APPLICATION NO. 03-00647	PROJECT NO. 1002603
PROJECT NAME EAGLE ROCK EST., UNIT 1	
EPC APPLICATION NO.	
APPLICANT / AGENT MARK GOODWIN & ASSOC	PHONE NO. 828-2200
ZONE ATLAS PAGE C-19	
(SDP for SUB), (SDP for BP), (FINAL PLATS), (MASTER DEV PLAN), (IR), (AA)	
ONE STOP COMMENT FORM LOG

CITY OF ALBUQUERQUE
PLANNING DEPARTMENT
DEVELOPMENT REVIEW BOARD

MARK GOODWIN & ASSCO agent(s) for SUNSET WEST request(s) the above action(s) for all or a portion of Tract(s) A & B < known as Public Drainage Easements >, **EAGLE ROCK ESTATES, UNIT I, POND RECLAMATION**, zoned R-D/7DUac, located on MODESTO AVE NE, between LOUISIANA BLVD NE and VISTAS DR NE containing approximately 8 acre(s). [REF: DRB-97-375] [Deferred from 5/21/03] (C-19)

CORRECTION PLAT OF
 TRACT A, BLOCK 1
 AND
 TRACT B, BLOCK 2
 EAGLE ROCK ESTATES
 UNIT 1

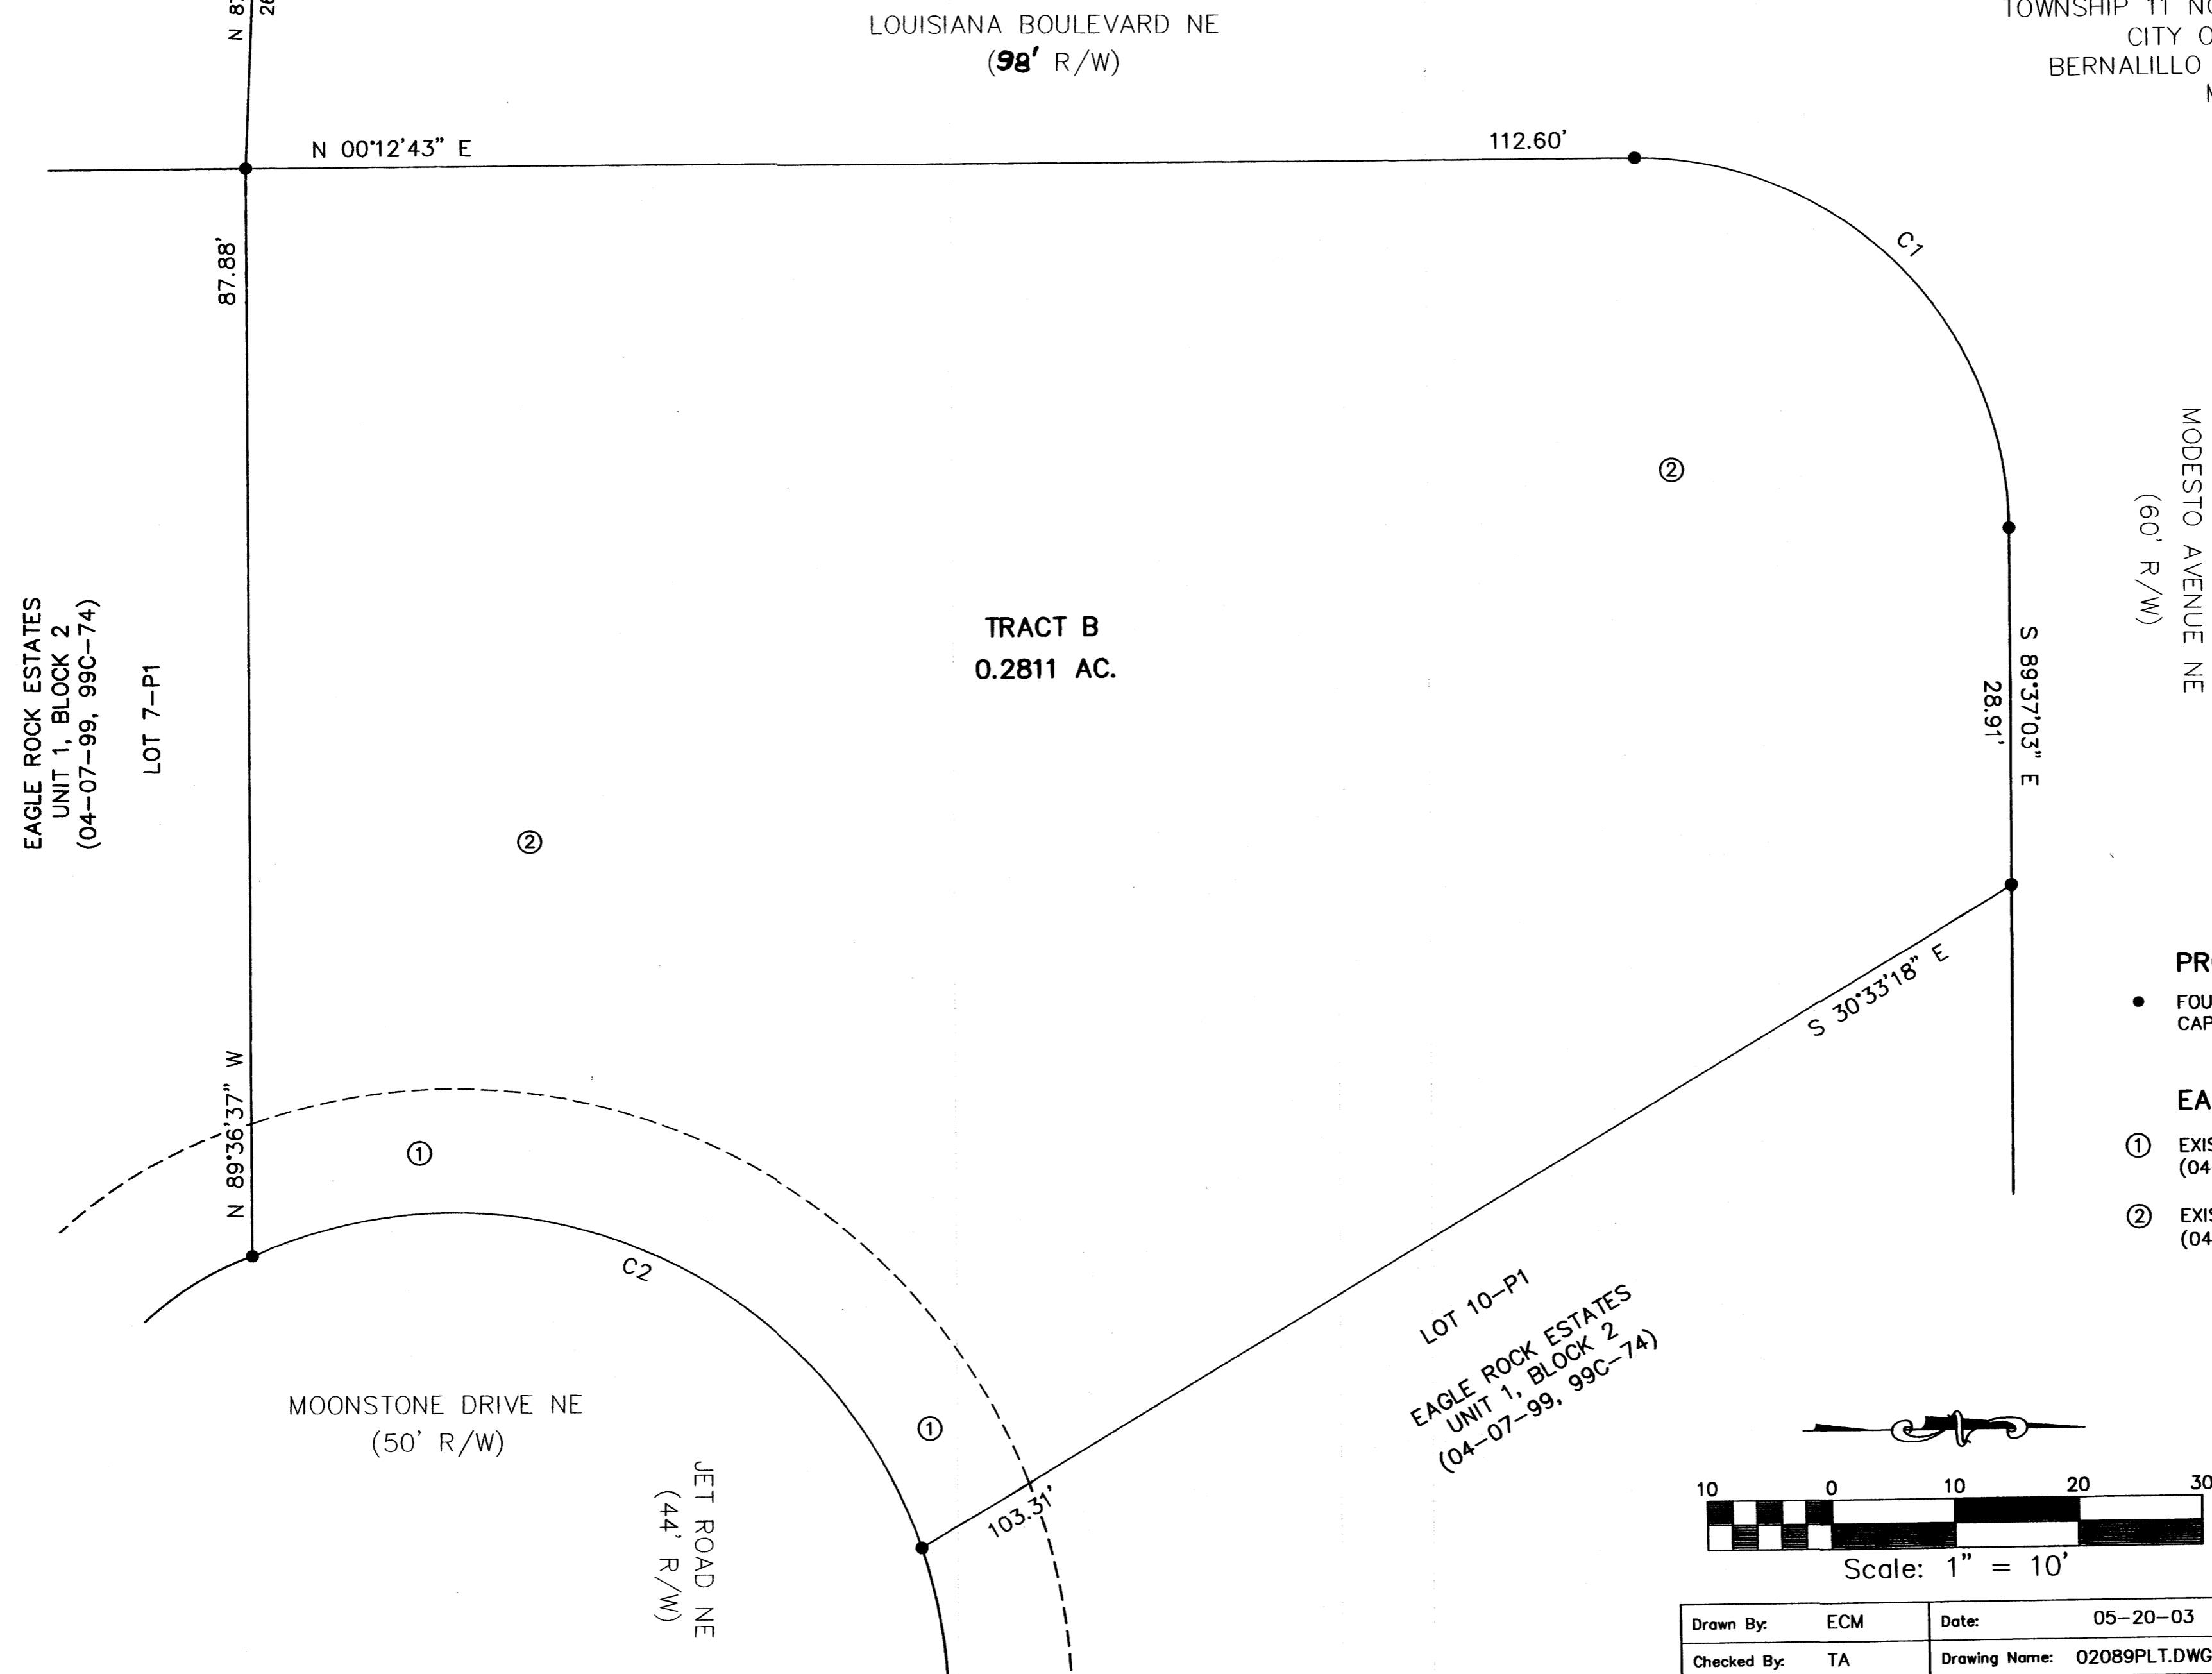
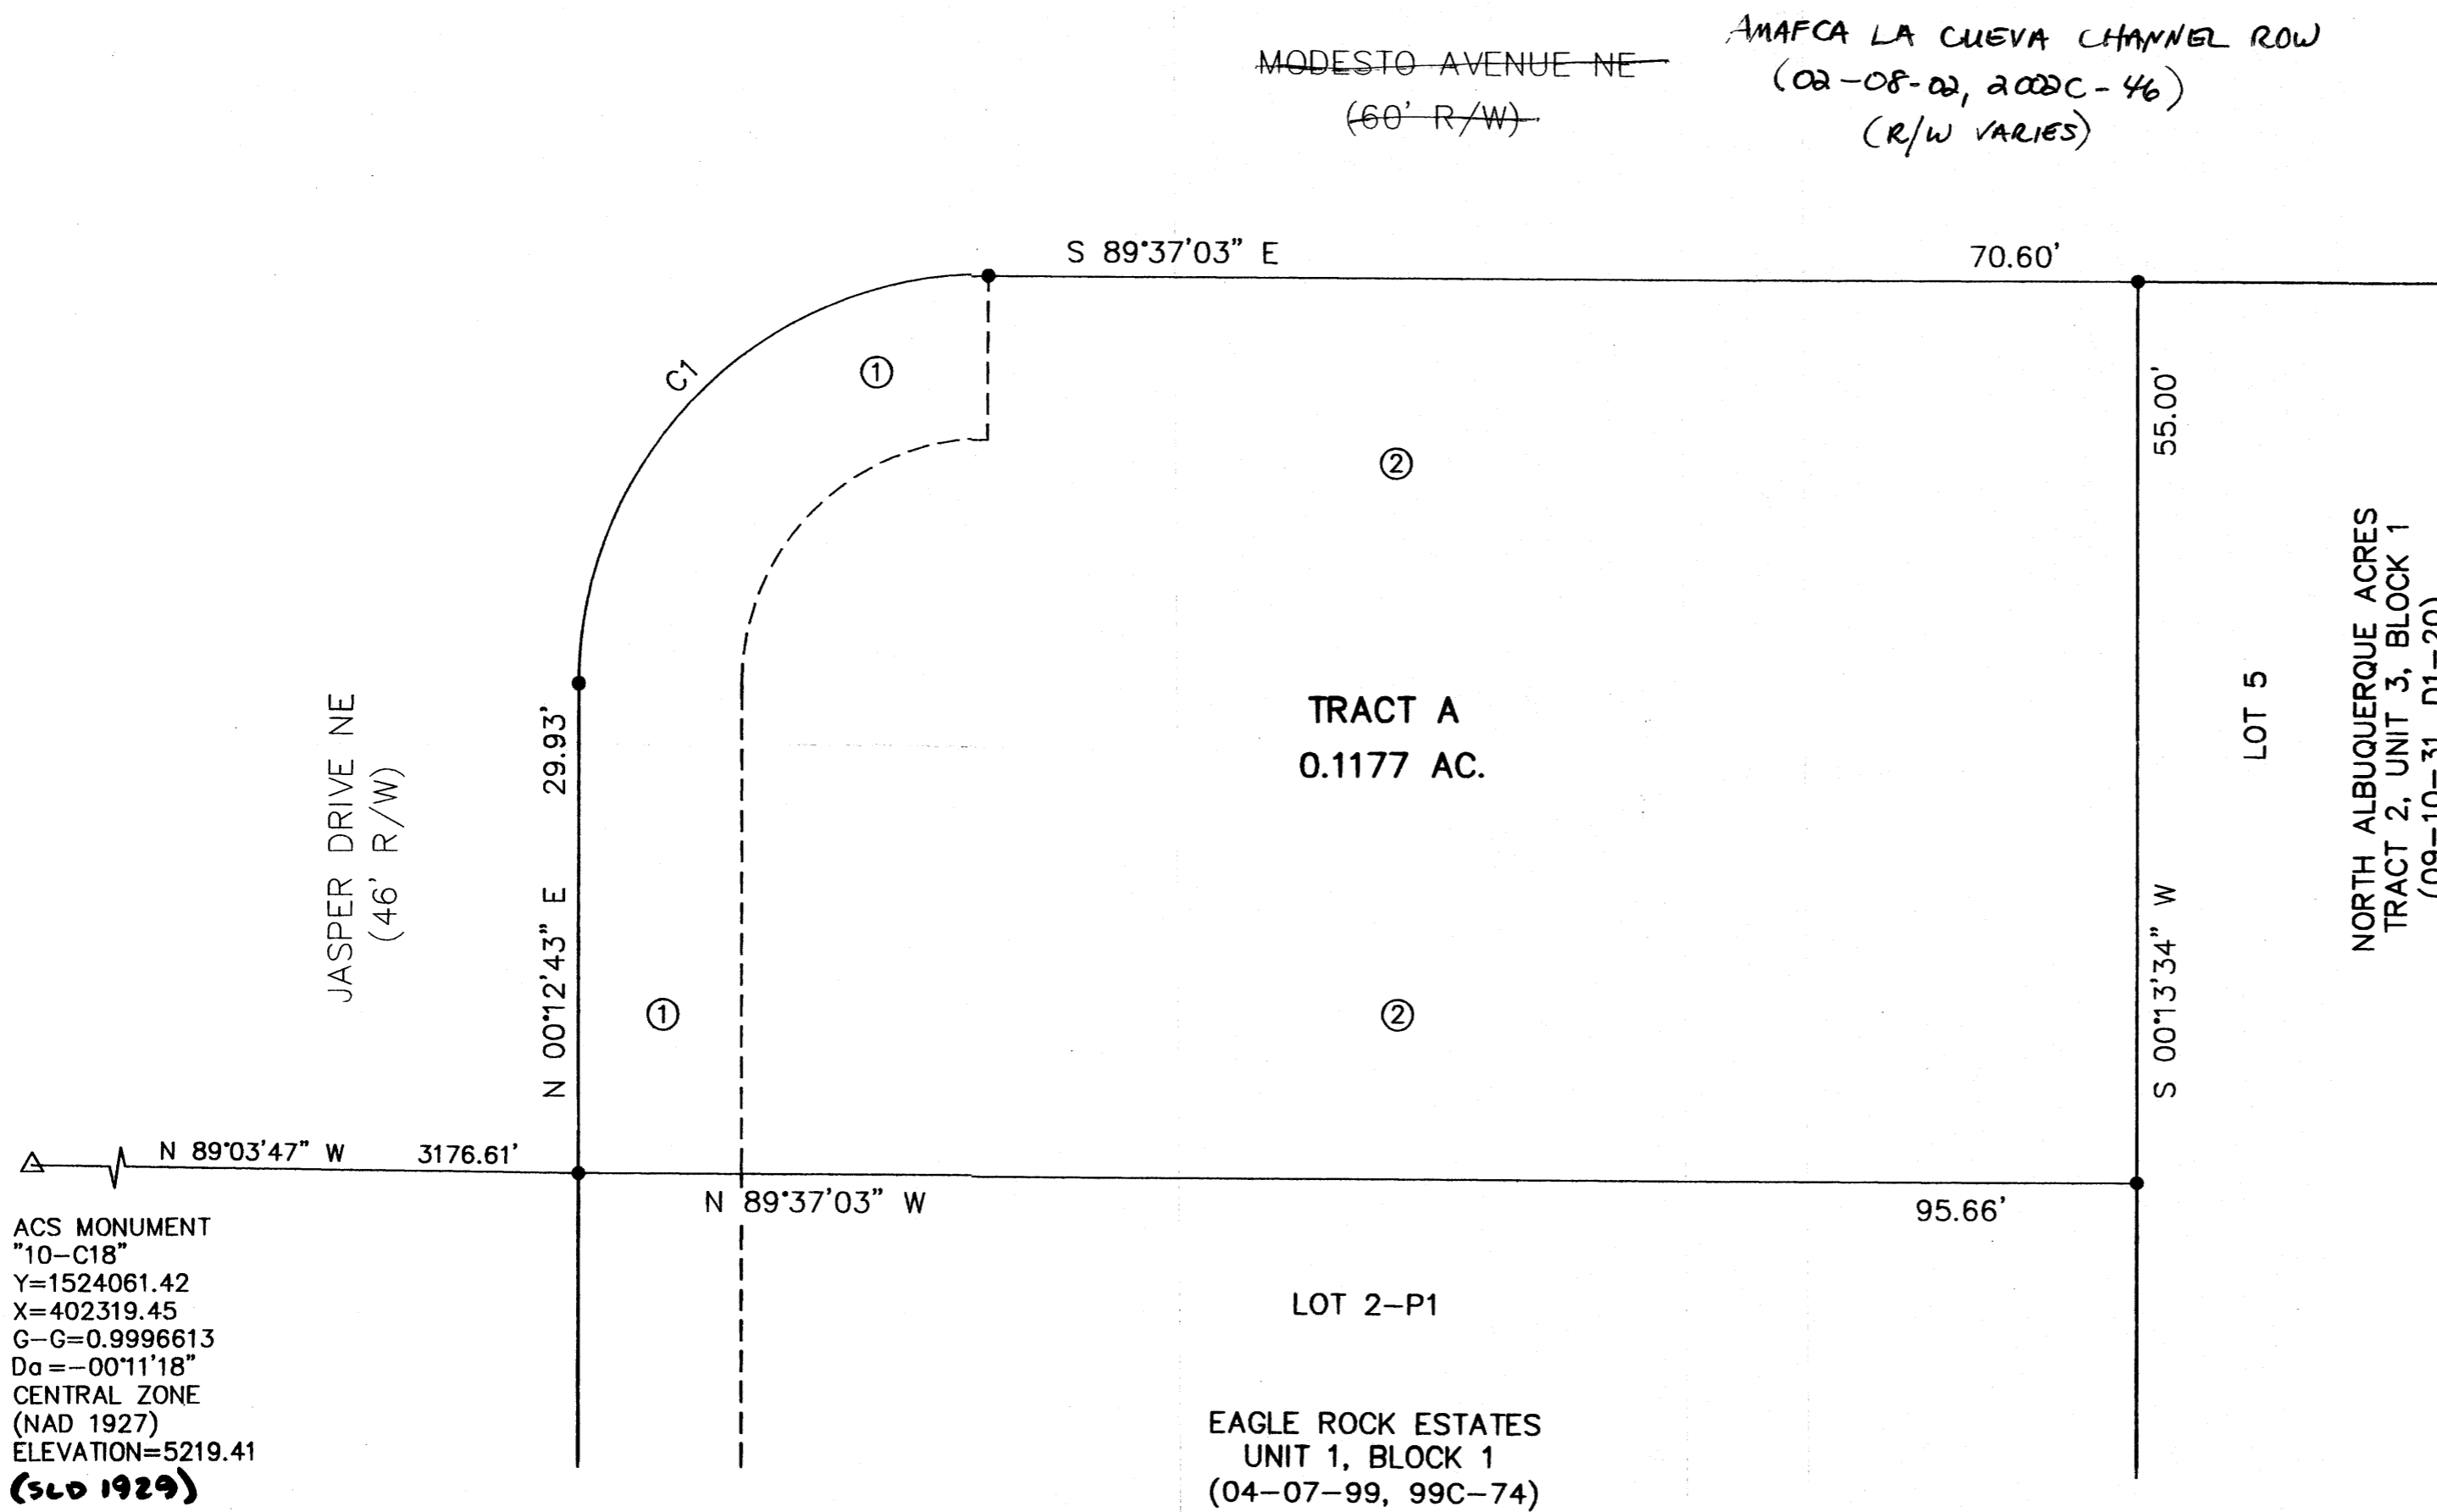
Amy Driscoll is going to submit a correction plat for this subdivision giving the pond a legal description on the plat. You & I will need to sign (or initial) it. Then they will re-submit the new plat. We deferred the case for ~~one~~ ² weeks.

The Hydrology Section has no objection to the vacation request.
 Need correction plat to define tracts being subdivided.
 An approved drainage plan dated 4-22-03 is on file for Preliminary Plat approval.
 Engineer's Certification of the grading plan is required for Final Plat sign-off.

No objection to Vacation requests. Prior to approval of Final Plat, a Correction Plat must be done on the original plat to give temporary public drainage easements a tract designation.
